An
Coimisiún
Pleanála

**Specialist Report to
Inspector
(Appendix to main
report)
ABP-321454**

Development	Brittas wind farm: Proposed development of 10 Wind Turbines, 110kV Electrical Substation and ancillary development within the townlands of Brittas, Rossestown, Clobanna, Brownstown, Killeenleigh, Kilkillahara, Brittasroad, Coolgarrane, Athinid More, Cassestown, Laghtagalla, Farranreigh, Furze, Loughlahan, Ballygammane, County Tipperary.
Type of Application	Strategic Infrastructure Development (SID)
Topic:	Adequateness of information for Appropriate
Appropriate Assessment	Assessment and EIA- Biodiversity and
EIA: Biodiversity	Ornithology
Ecologist	Maeve Flynn BSc. PhD. MCIEEM
Senior Planning Inspector	Rachel Gleave O'Connor

Directional Drill under Watercourse Crossing Scale 1:100

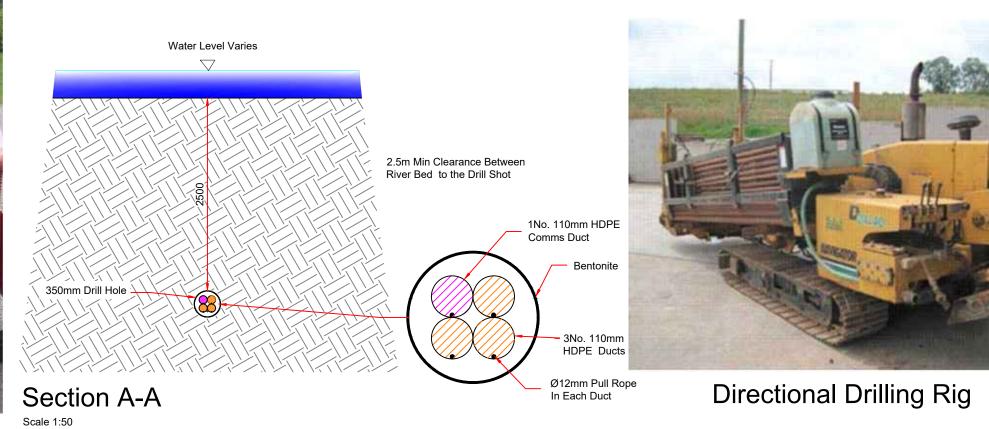
- 2.2.5. Seven watercourse crossings are stated to be required for access roads and underground cables. Five of these are within the wind farm site with one crossing of the River Suir required via horizontal directional drilling (HDD) and a further two river crossings of tributaries of the River Suir for the offsite grid connection. There is an absence of detail on location of works areas for the HDD crossings in the NIS.
